DECISION DELEGATED TO HEAD OF PLANNING

Application No: H17-0831-24 **Applicant:** NNA Surfleet Limited

Proposal: Details of self-build properties, site & floor levels, hard surfaced areas & garden/amenity areas, foul & surface water disposal, construction management plan & method statement, works to trees & means of construction, drainage & surfacing of the access drive including a method statement for the protection of existing trees (Part Conditions 3, 7, 8 & 12 & Full Conditions 14 & 15 of H17-0357-22)

Location: Land Off Thary Lane Surfleet Spalding

DRAWING NUMBER 524.CEMP.01

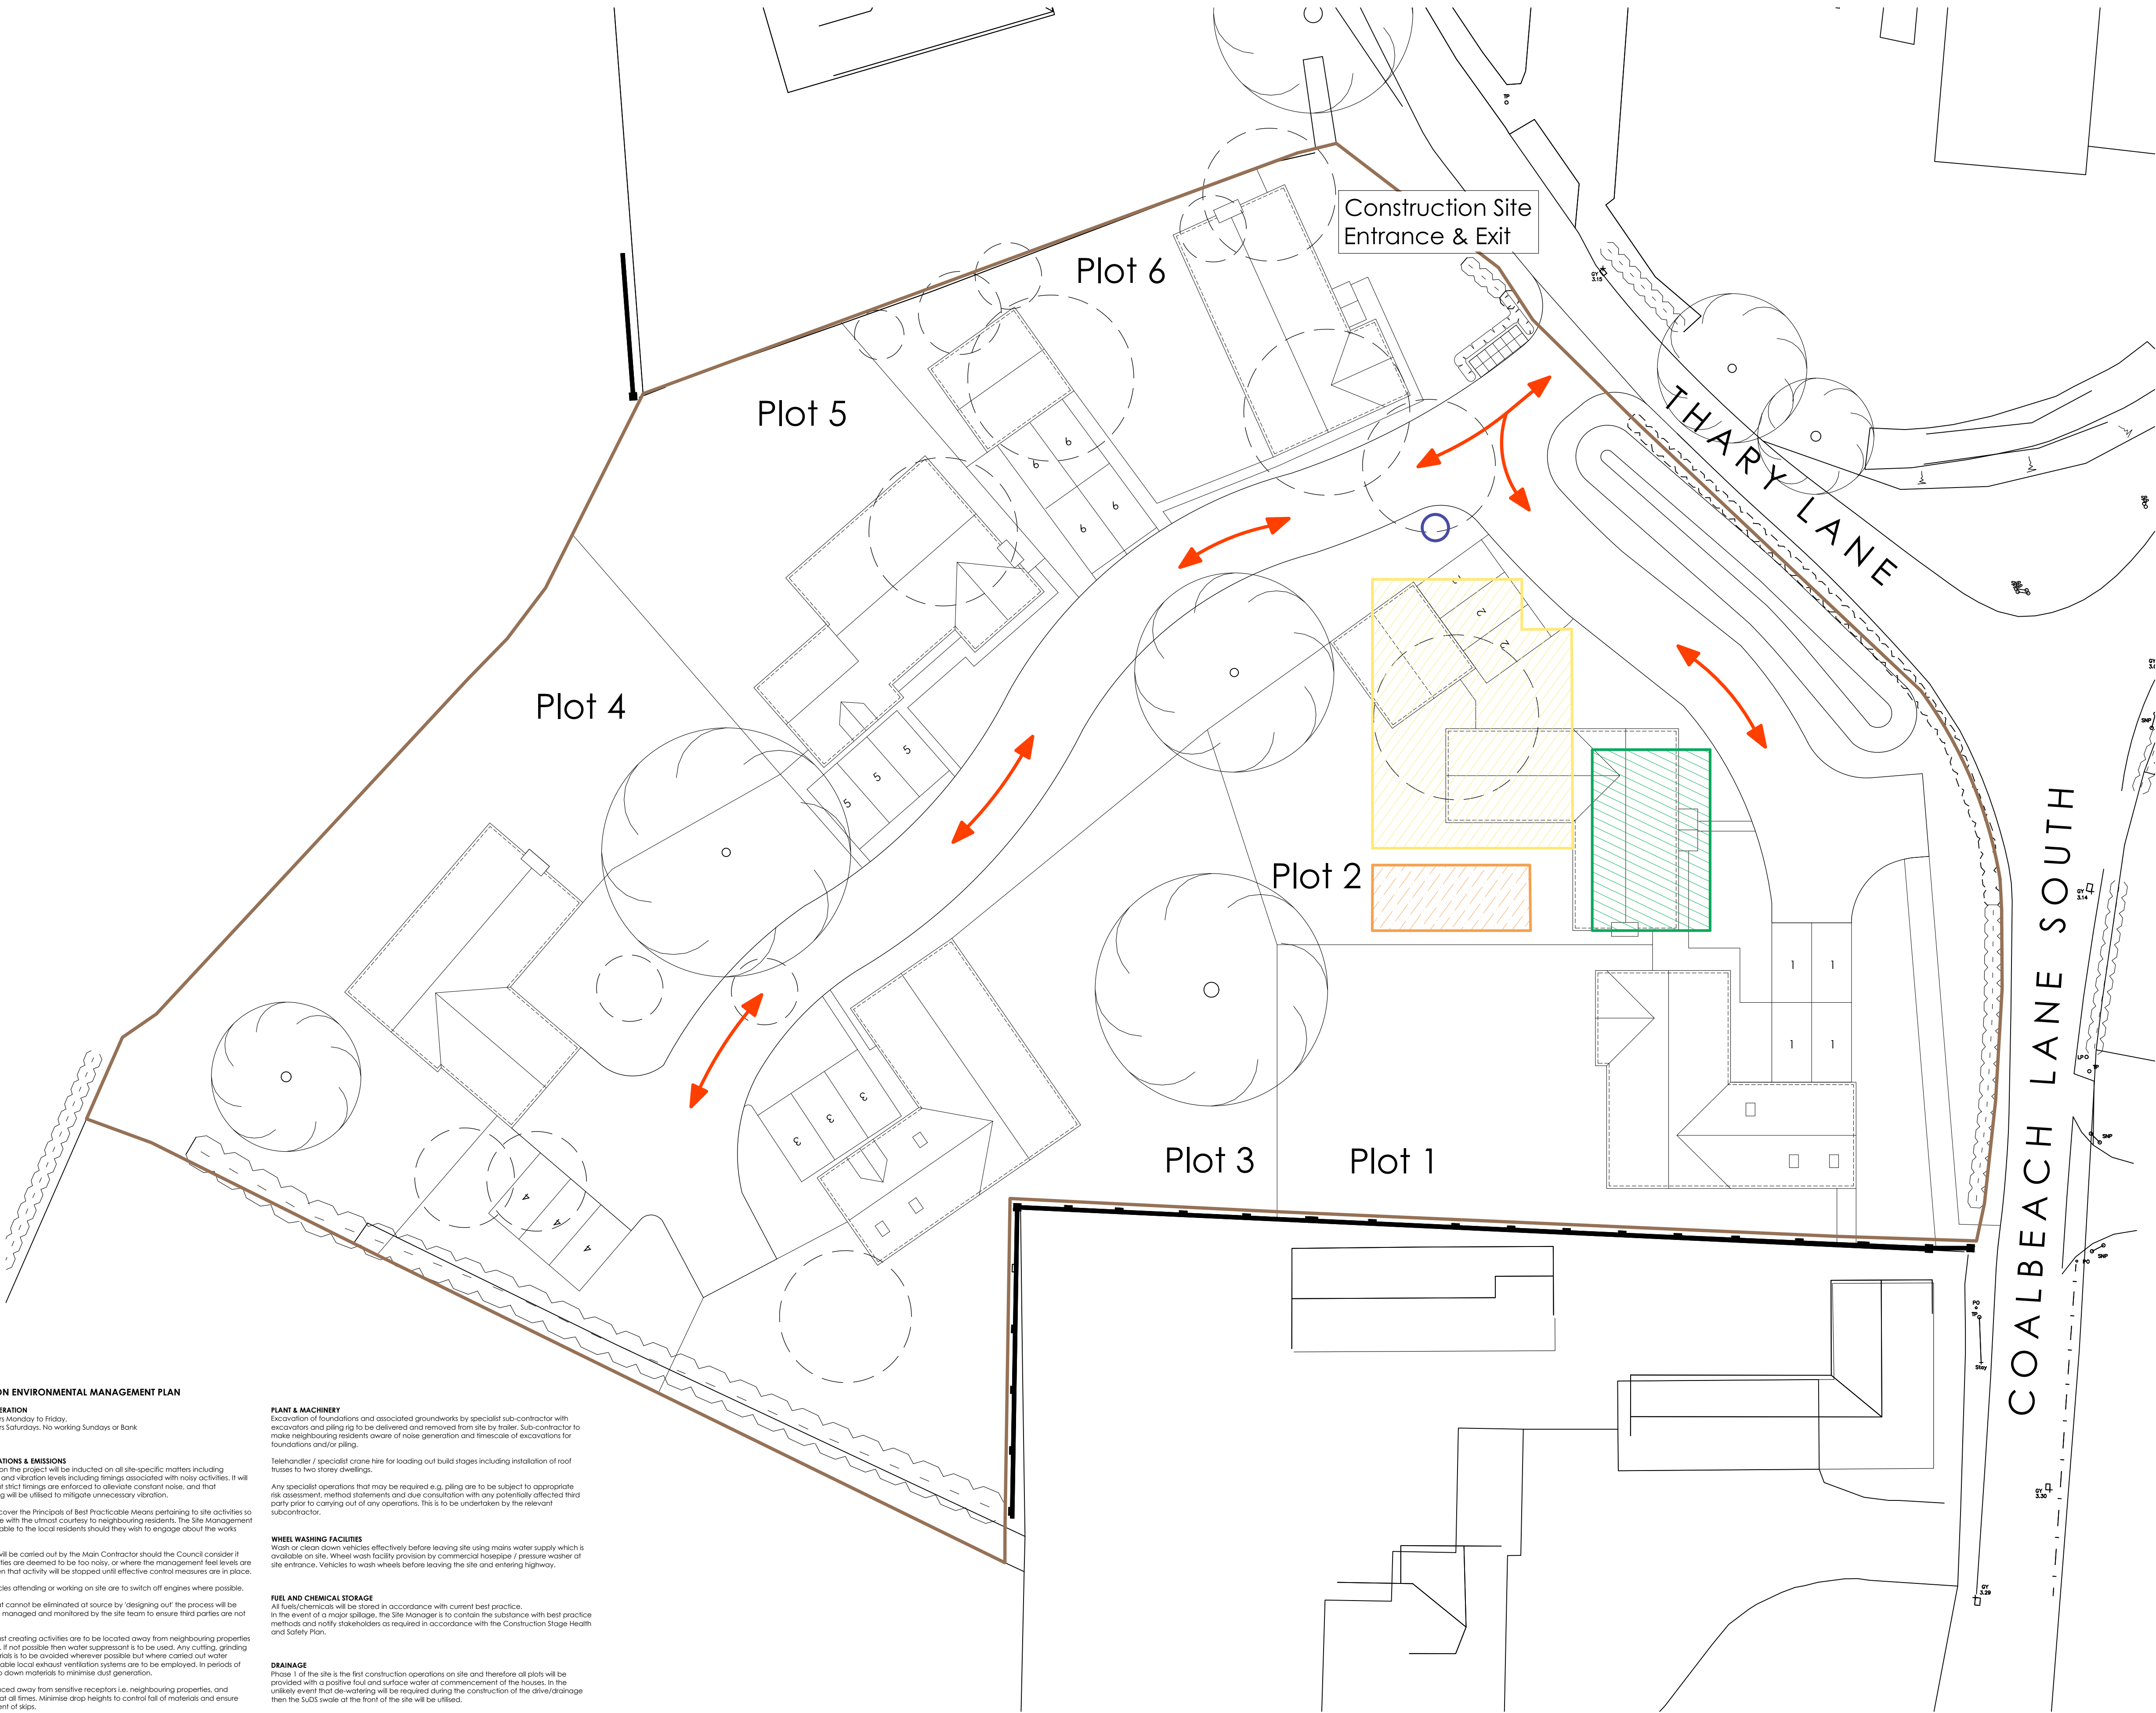
The details submitted to discharge condition 12 attached to H17-0357-22 are acceptable in accordance with approved drawing 524-CEMP.01 dated 18-09-24.

The applicant has submitted a construction environmental management plan as far as work relating to private drives and sewers. Highways have reviewed the information and consider it acceptable. Condition 12 remains extant as the applicant only seeks part discharge the nature of the condition does not allow this approach.

DRAWING NUMBER 524.CSL.01

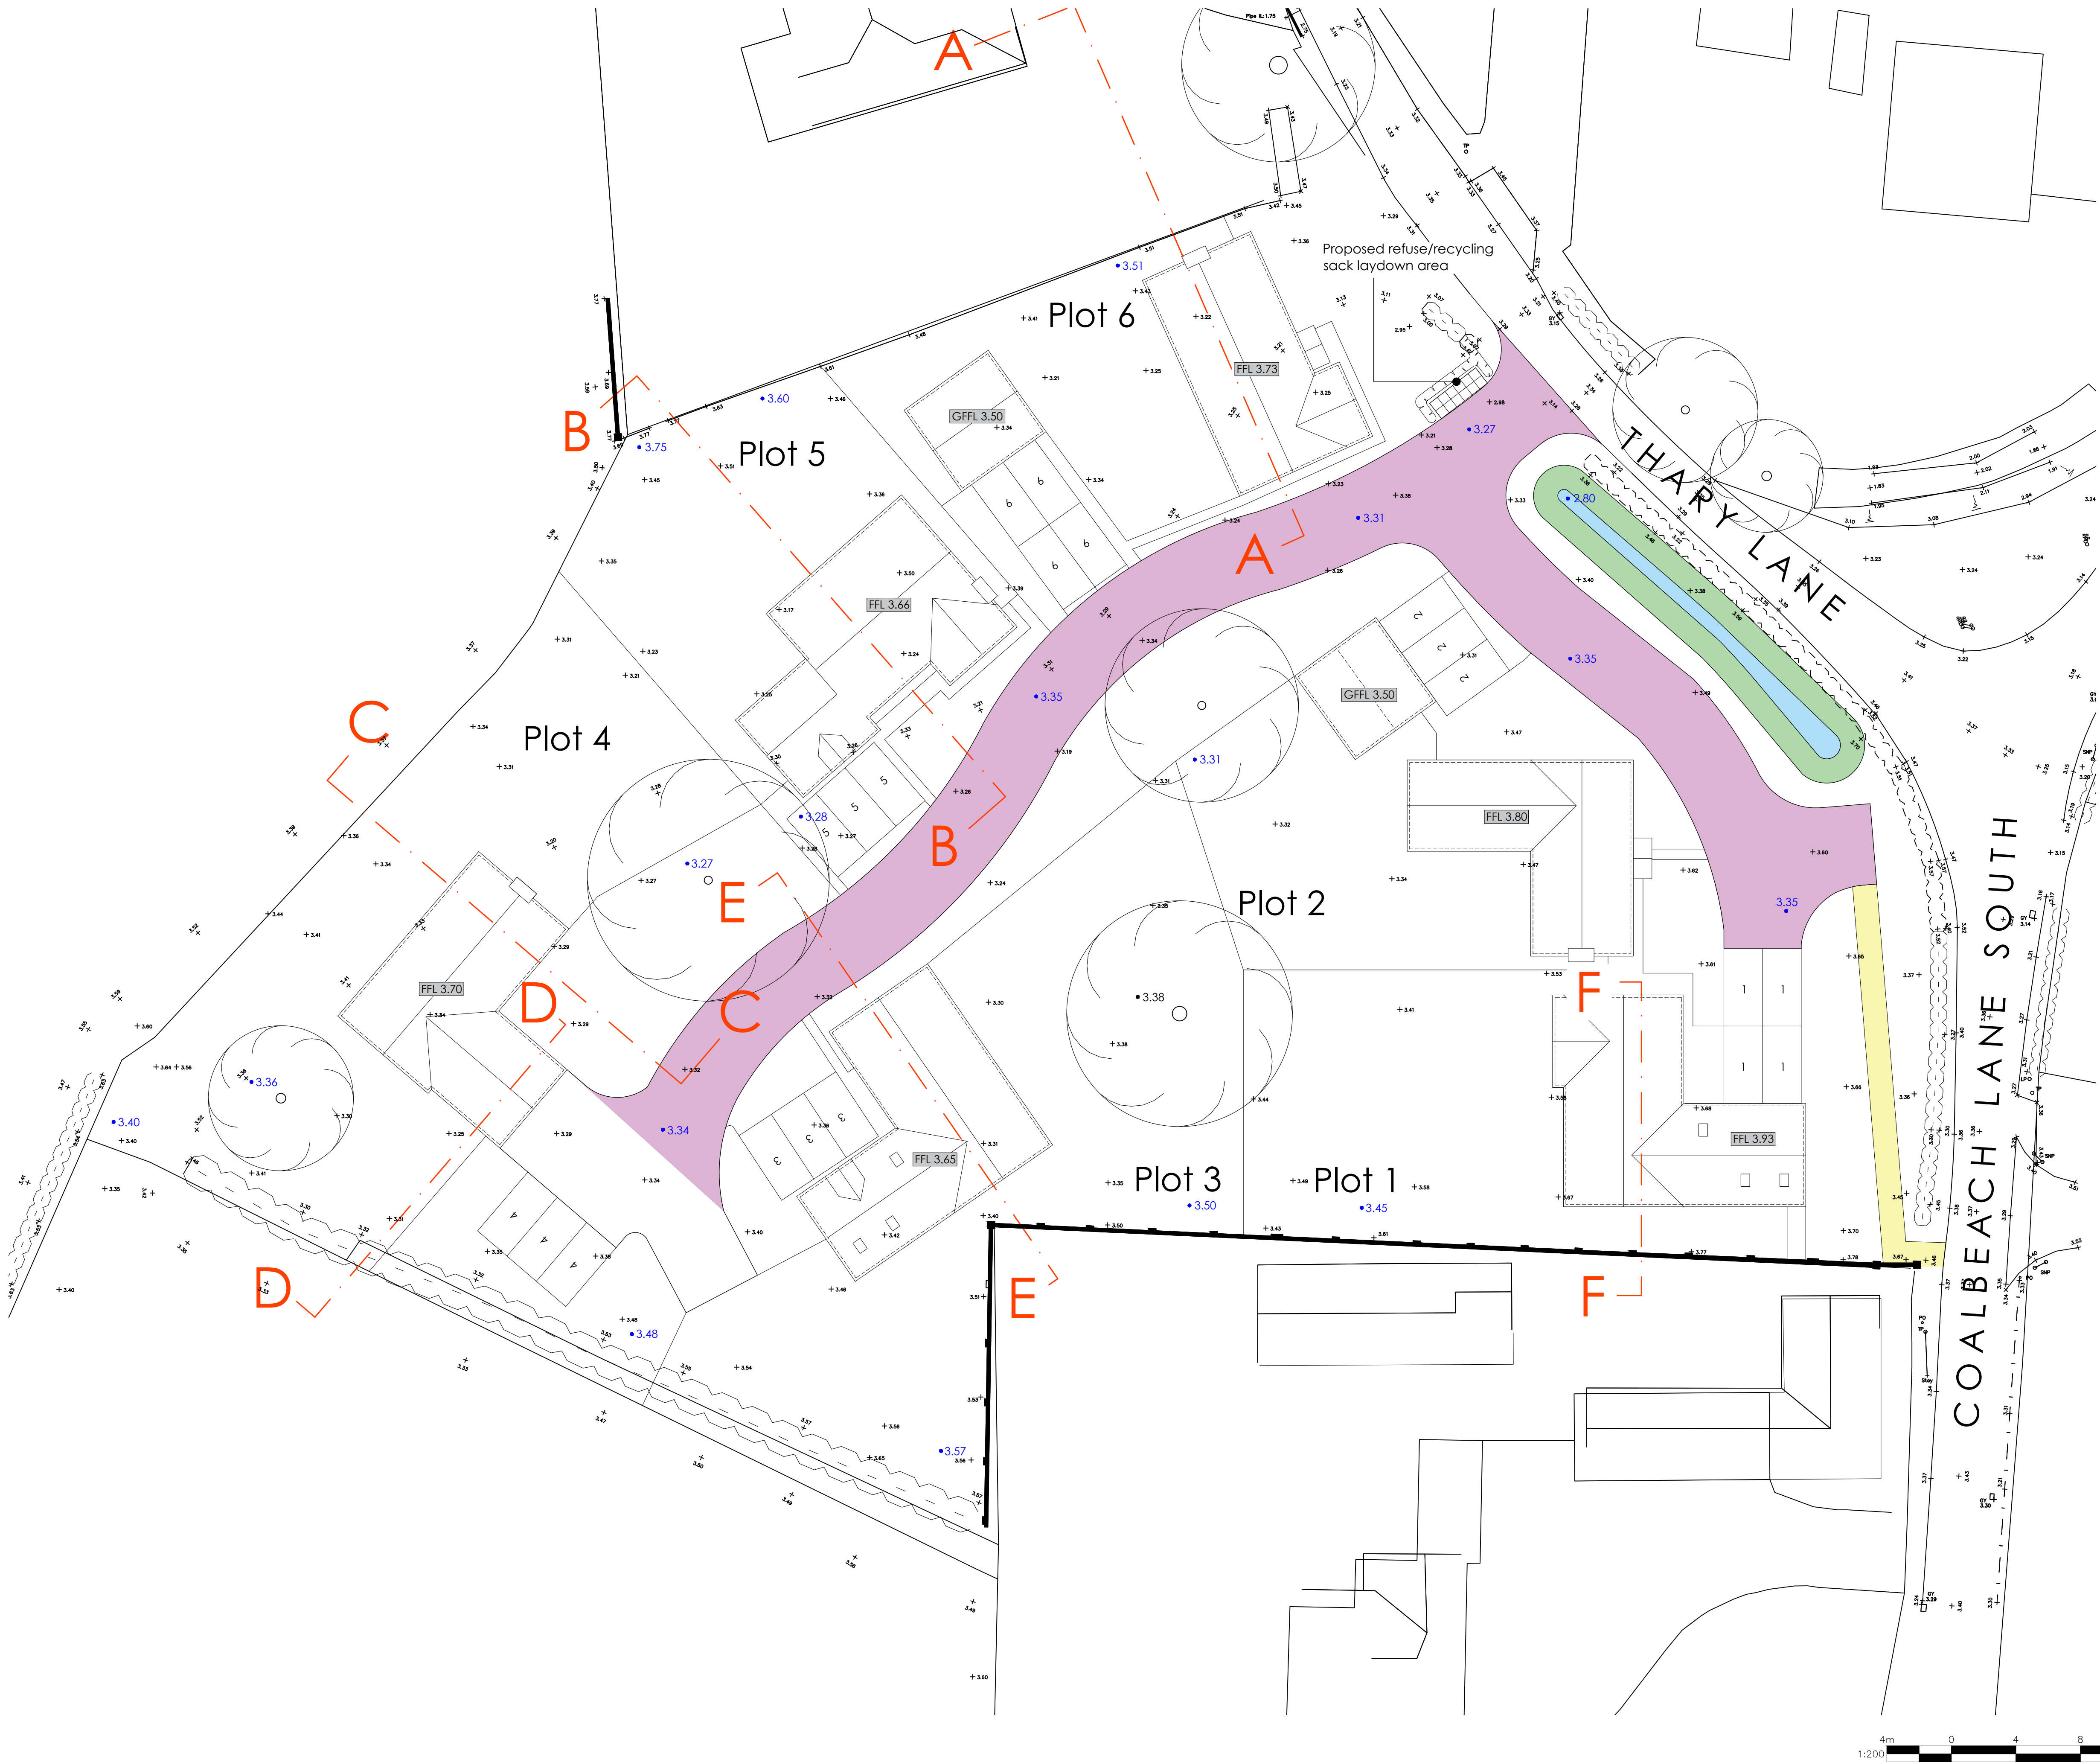
This condition cannot be discharged. Whilst the levels relating to roads may be acceptable, information on the FFLs relating to building is required. Whilst the applicant only seeks part discharge the nature of the condition does not allow this approach.
